CITY OF ALBUQUERQUE

October 22, 2019

Re: Pando Daycare
3504-3506 Anderson Ave SE
Traffic Circulation Layout
Engineer's/Architect's Stamp 10-21-19 (L16D041)

**A1 SITE PLAN**  
3/32" = 1'-0"

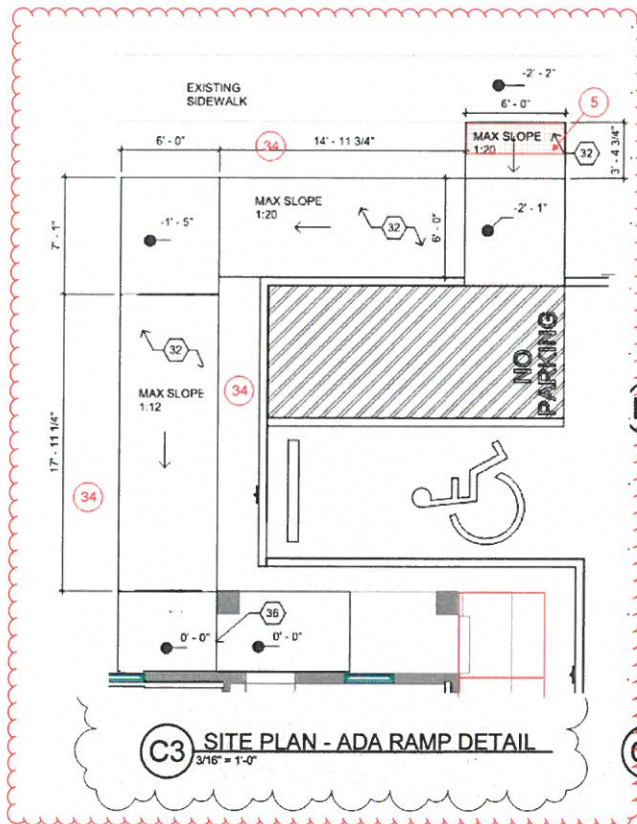
1. When requesting CO please remove city standard drawing 2440 from TCL.
